**RE: LACUEVA CORONA SUBDIVISION (C19-D6). GRADING AND DRAINAGE PLAN
FOR FINAL PLAT APPROVAL. ENGINEER'S STAMP DATED MARCH 6, 1997.**

***RE: Grading and Drainage Certification for La Cueva Corona Subdivision (C19/D6)
Submitted for Release of Financial Guarantees, Engineer's Stamp Dated 1/5/99.***

RE: LA CUEVA CORONA SUBDIVISION (C19-D6). UPDATED GRADING AND DRAINAGE PLAN FOR FINAL PLAT, GRADING, AND PAVING PERMIT APPROVAL. ENGINEER'S STAMP DATED NOVEMBER 21, 1997.

**RE: LACUEVA CORONA SUBDIVISION (C19-D6). GRADING AND DRAINAGE PLAN FOR
PRELIMINARY PLAT, FINAL PLAT, AND GRADING PERMIT APPROVAL. ENGINEER'S
STAMP DATED JANUARY 17, 1997.**

LA CUEVA CORONA SUBDIVISION GRADING & DRAINAGE PLAN

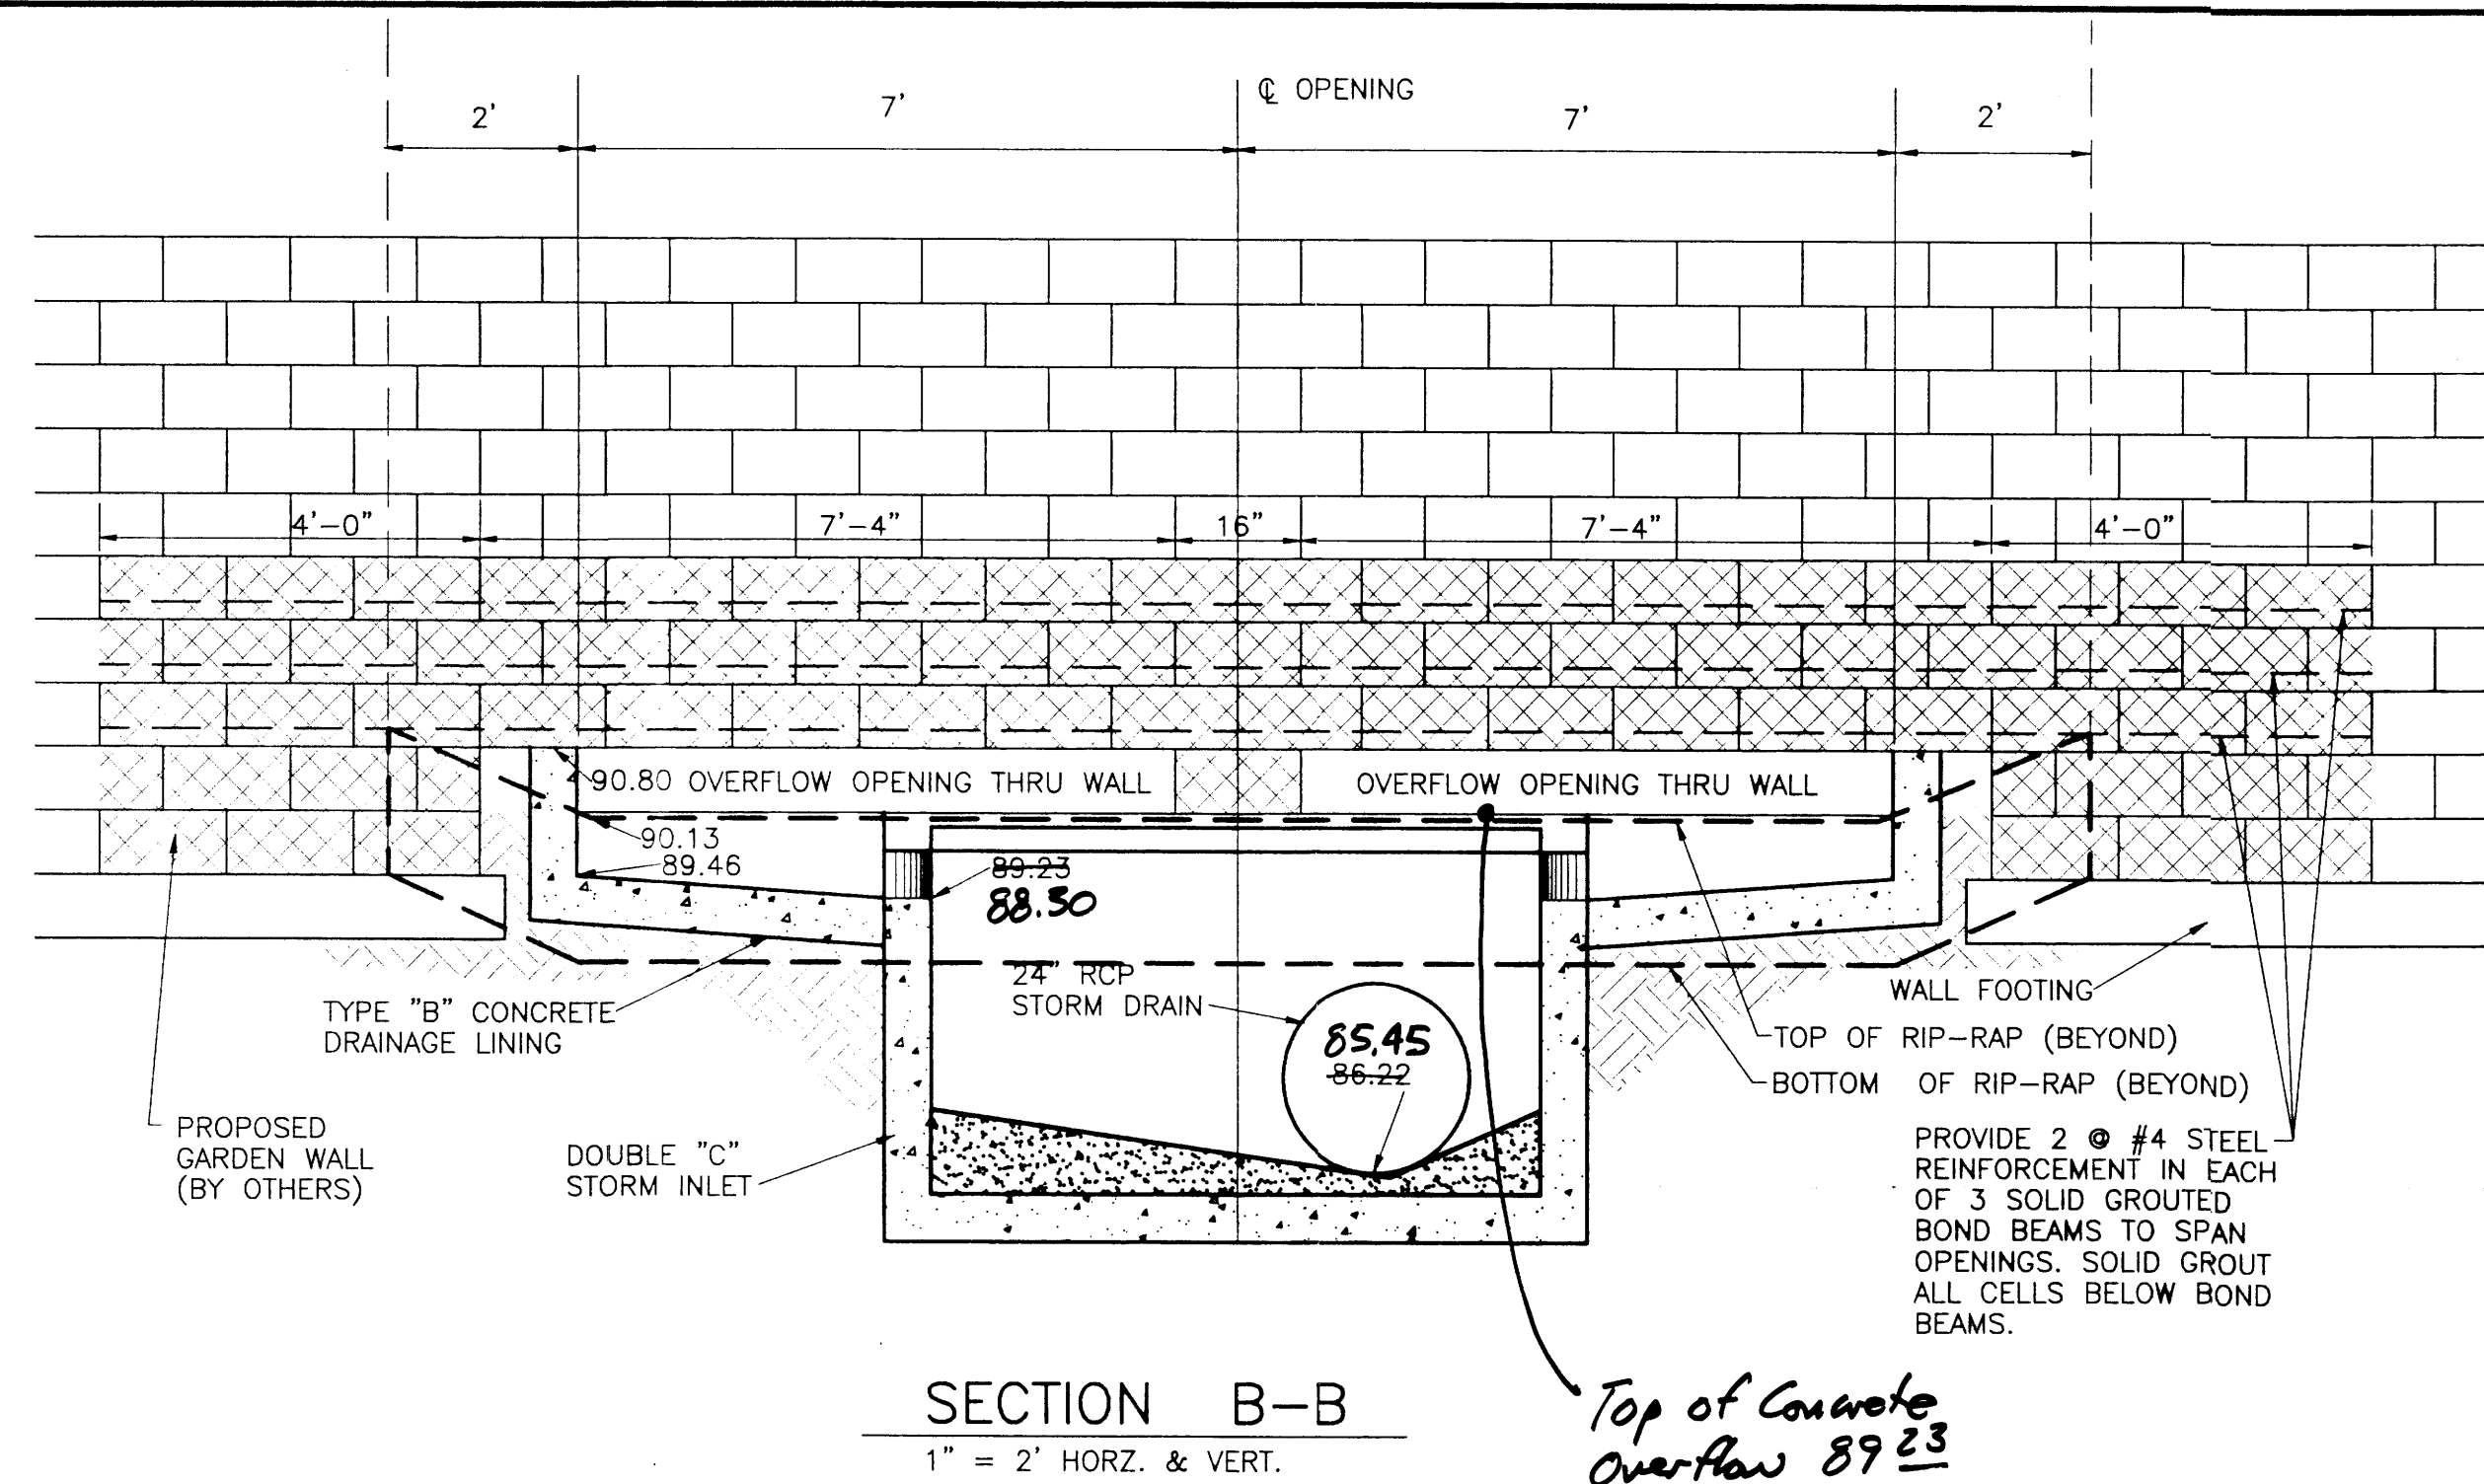
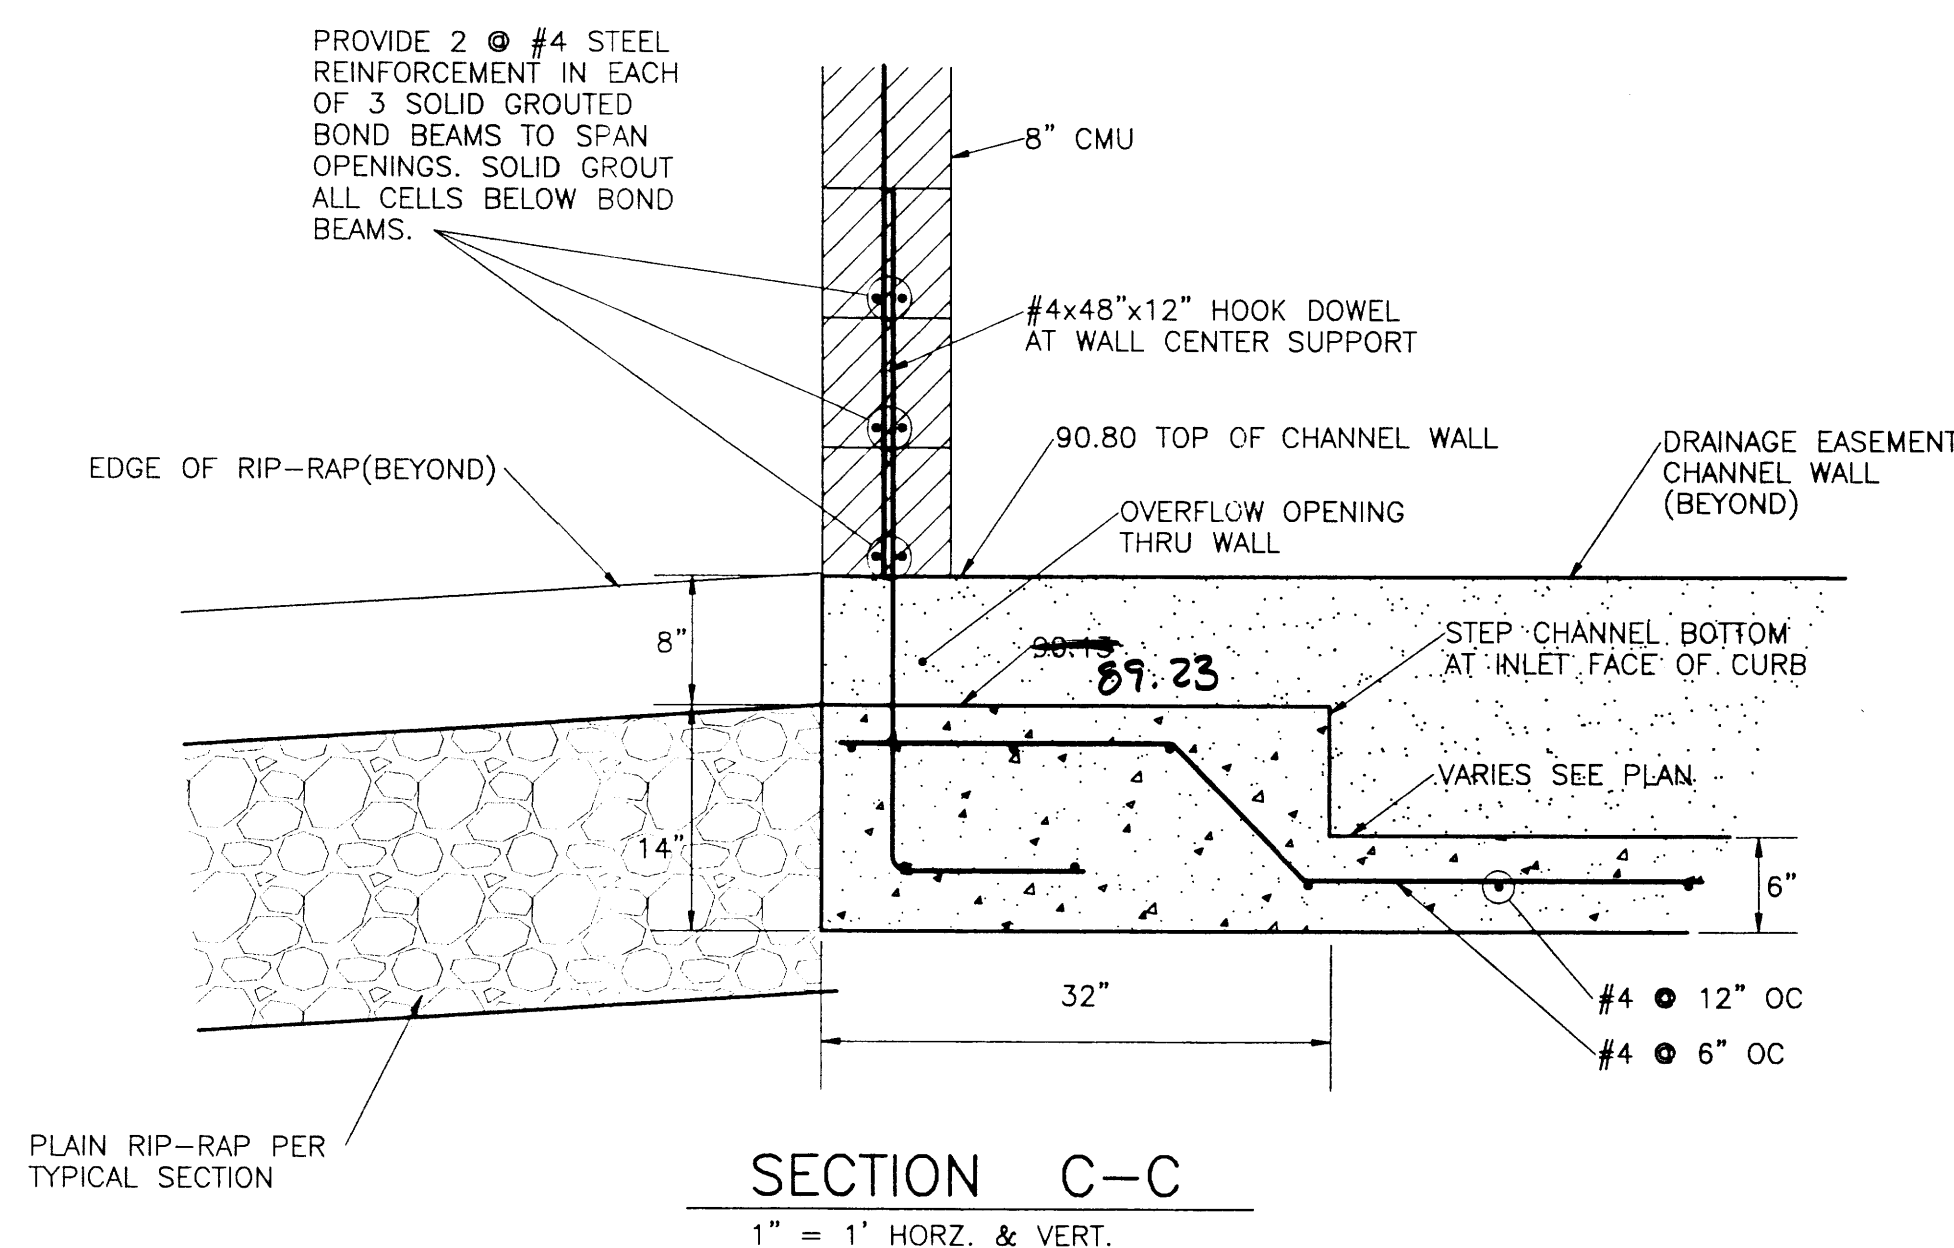
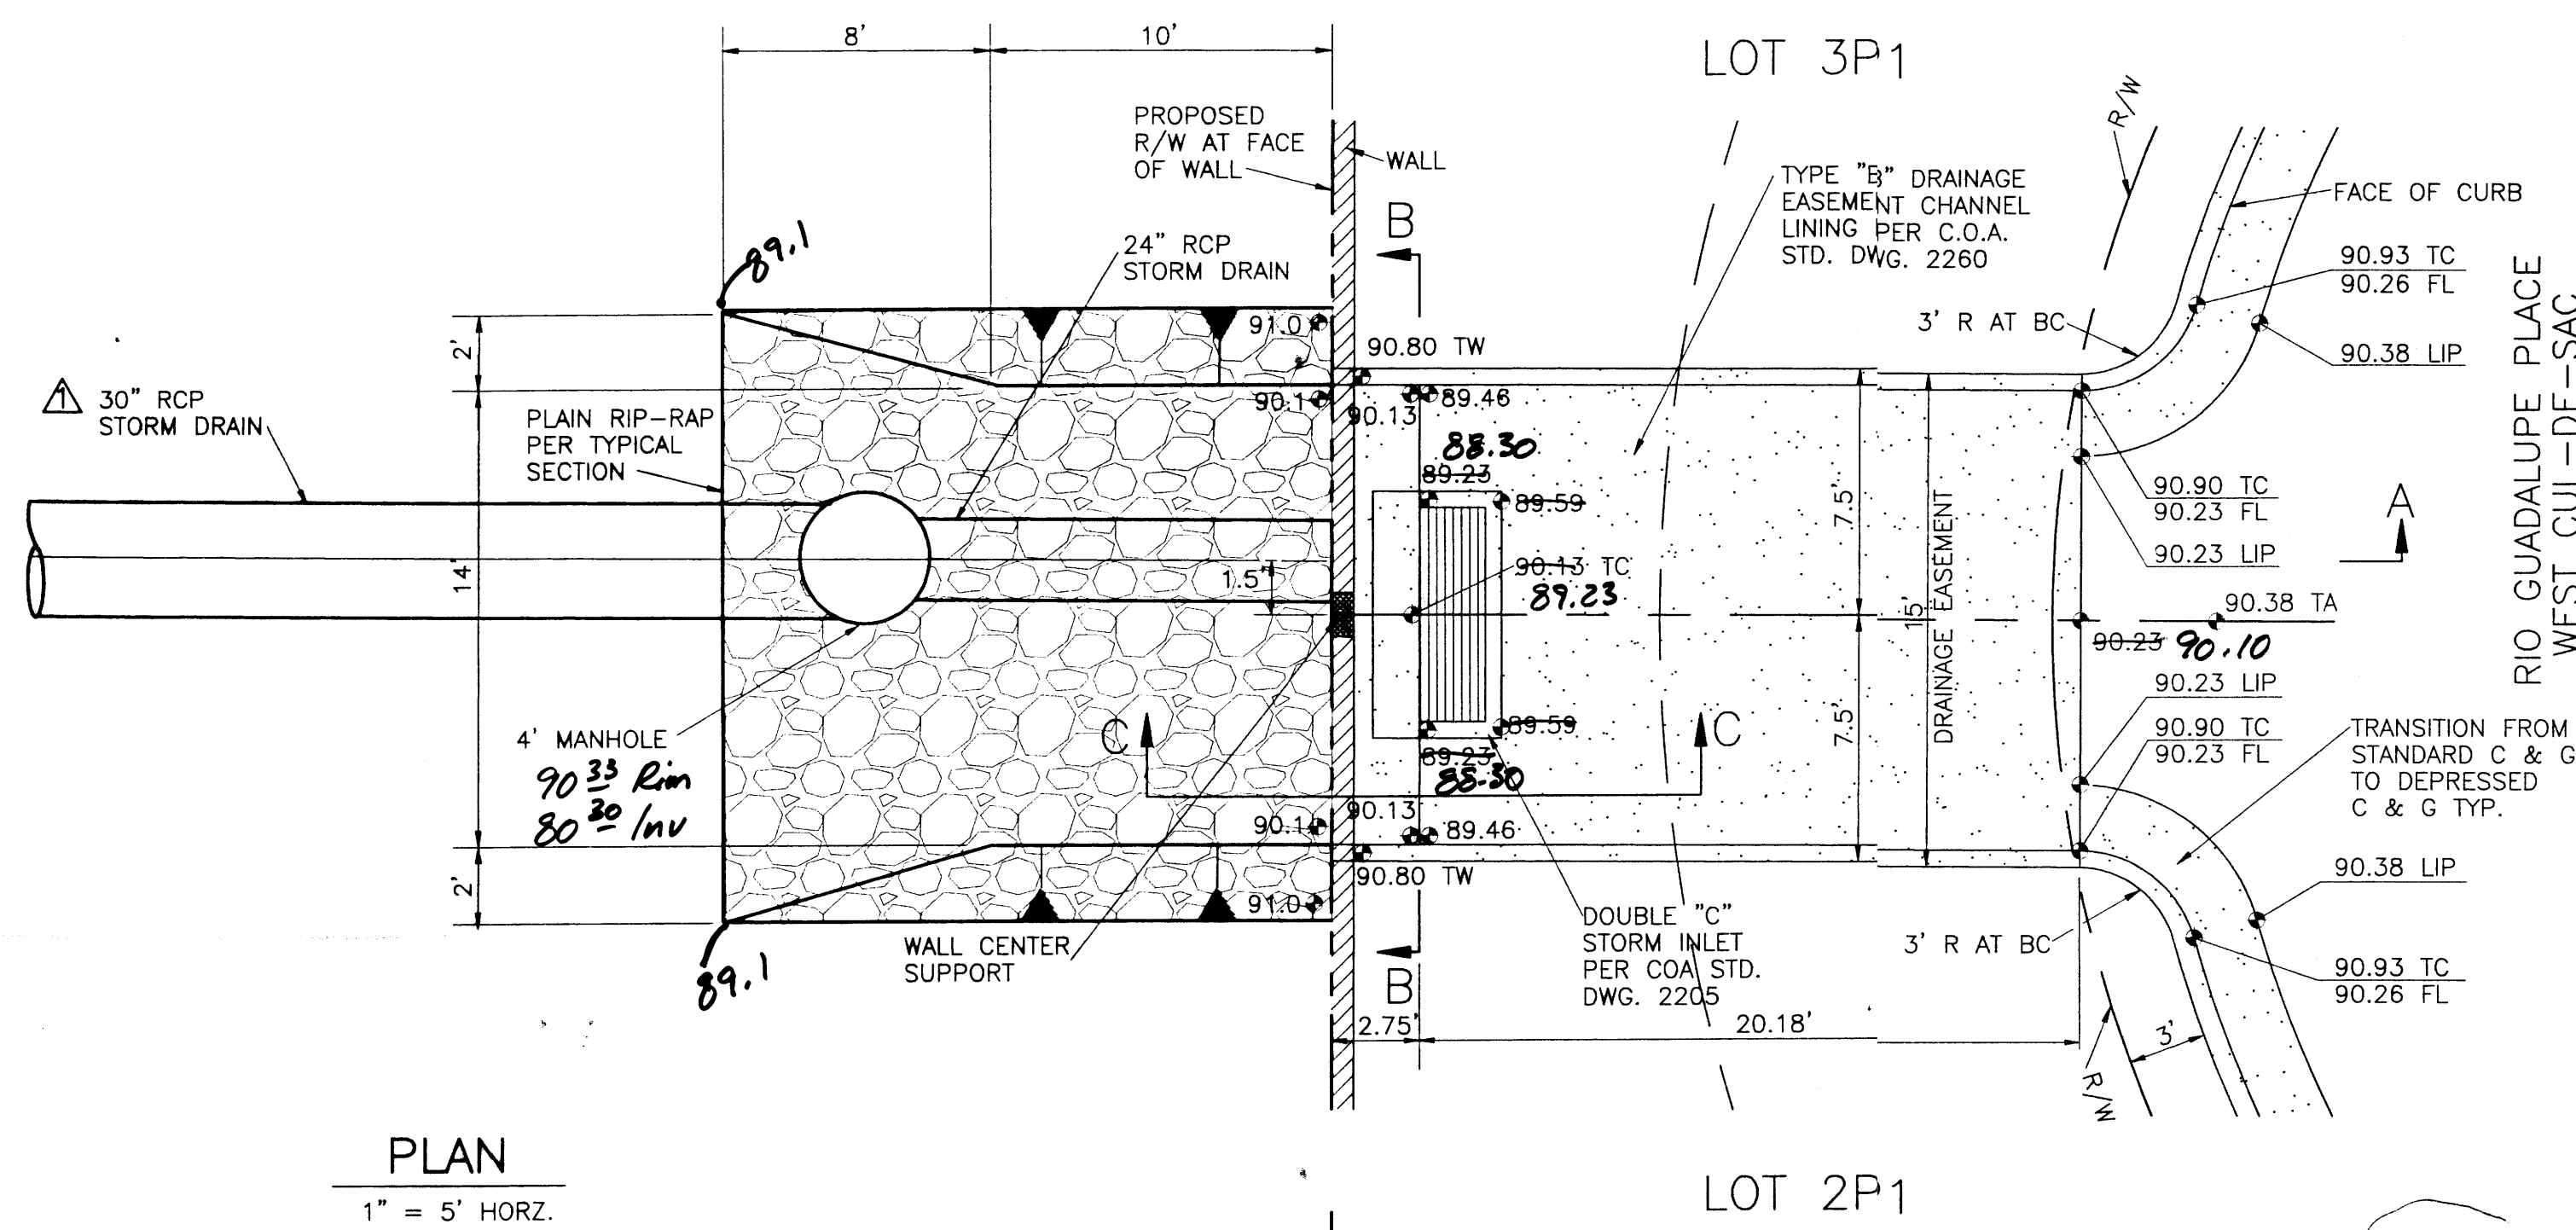
1. Under the paragraph titled "METHOD," please delete the word "Conceptual."
2. Prior to final plat approval, a maintenance agreement for the temporary retention pond will have to be resolved.
3. You will need to fence the 3-foot retention pond. Retention ponds greater than 18-inches must be fenced.
4. Show finish pad elevation to mean sea level.
5. On section A-A, show future 24-inch RCP from pond to Wyoming. The details can be cleared up at DRC, however, I'd like to see the general idea on the referenced section.
6. Provide an overflow for the double "C" inlet.
